Design Evolution Document

Pendle Road, Clitheroe, Phases 5 & 6

Created on behalf of Taylor Wimpey
May 2026

Revision A

Drawing Title:  
**Composite Site Layout 5 & 6**

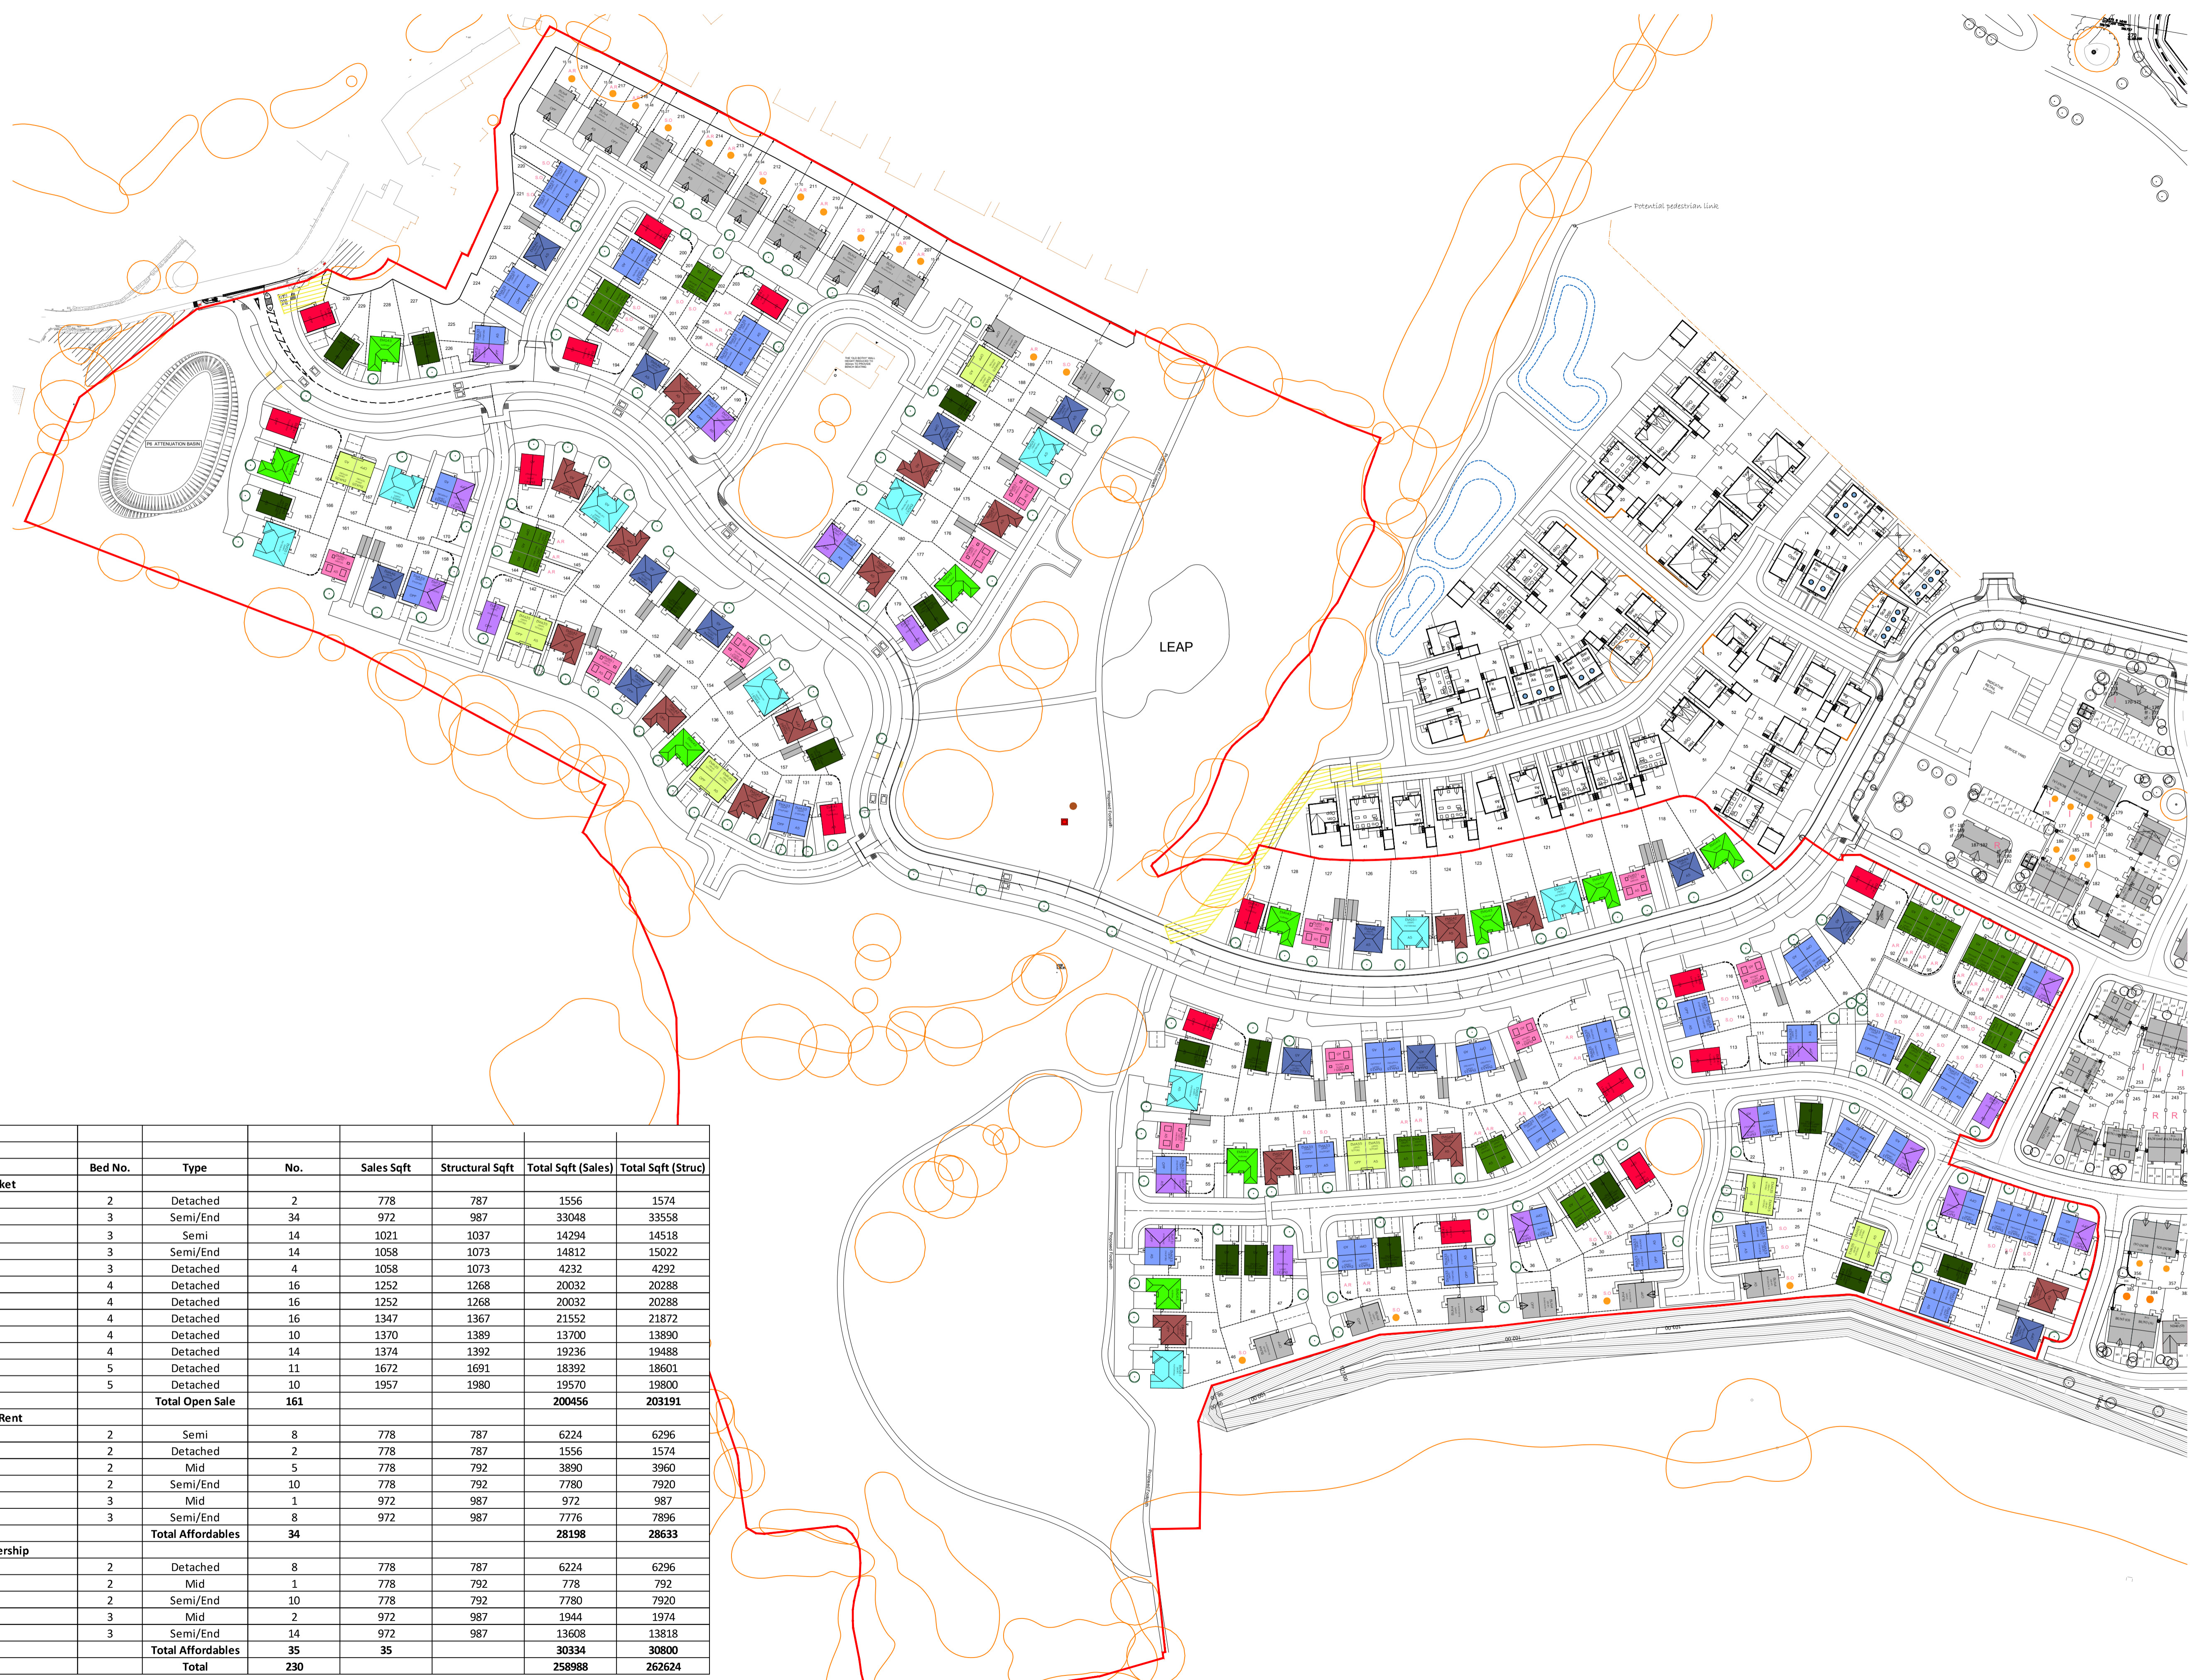
- 1 The development north of the spine road now faces it to provide an active frontage.
- 2 The dwellings which front the southern side of the spine road are now accessed via private drives, this reduces the amount of vehicular accessways crossing the 3m pedestrian / cycle way.
 - a This has resulted in an overall loss of dwellings (from 265 to 230 houses), mix changes and structural layout changes.
- 3 The turning facility marked (right) has moved south, away from the retained trees to ensure that it is clear of a root protection area.
- 4 The access road marked (right) has been removed, limiting the overall amount of hardstanding while retaining the frontage over the adjacent buffer zones
- 5 Footway connectivity through areas of public open space have been reworked so that the pedestrian decants onto public accessways, forming logical routes throughout the site.

The dwellings north of the spine road on the previously submitted scheme were oriented towards the east and west. This previous orientation allowed for the accommodation of 22 dwellings within this parcel, while we achieved an active frontage by using corner turners facing the spine road.

The request to reorientate the dwellings north of the spine road has resulted in a reduction of 9 units as the current design features 13 houses within this parcel, albeit they are generally larger plots. This reduction in amount has had an effect on the development further within the site as we have tried to gain back dwellings elsewhere.

As the house types chosen for these parcels are larger, it has encouraged larger front garden areas and greater setback from the spine road. This, combined with the private drives south of the spine road allow the development to breathe.

The previously submitted scheme features plots with parking directly accessed from the spine road, this crossed the 3m pedestrian / cycle way. This has been mitigated on the current design by incorporating three private drives providing direct access.

To cater for the introduction of the private drives and the increase in land take, the dwellings highlighted mirror the previous phases to produce a cohesive street scene on both sides while ensuring that interface distances are adhered to.

The parcels which run along the southern boundary have been redesigned to allow for the set back of the dwellings facing the spine road. This redesign has included a reduction in houses and an overall mix change.

The incorporation of the private drives has made parcels smaller, this has caused the rotation of the units (left) allowing for a rear to side interface distance of approximately 14m is achievable.

Phase 6 used a similar design ethos surrounding parking for dwellings south of the spine road. The method for dealing with this was to introduce four private drives to limit the amount of vehicle crossing points over the cycle way. Only two of the four private drives are accessed from the spine road, providing a pedestrian led approach.

To ensure that a 21m interface distance between the rears of properties is achievable, the amount of units in parcels south of the spine have been decreased. This is evident on areas of development which face east and west.

The design changes along the spine road have decreased the size of parcels. To still retain the interface distances and the landscaped offset it was inevitable that units would be lost inside the development.

There are various large trees within the development, the aim is to retain these wherever possible. On the previous phase 6 design there was a turning facility within a root protection area. This redesign moved the turning head south, limiting the impact on these ecological assets.

The request to provide direct dwelling access via private drives south of the spine road while accommodating the 5m landscaped offset running parallel with the site boundary has resulted in the reorientation of parcels.

The new scheme provides an area of single-sided road and links the private drive, providing access to all dwellings which face the southern offset.

The previous design iteration included a pedestrian footpath from the south that decanted onto the end of a private drive. This current design offers a betterment on this, providing logical routes through areas of public open space. Allowing for connectivity throughout the wider site.
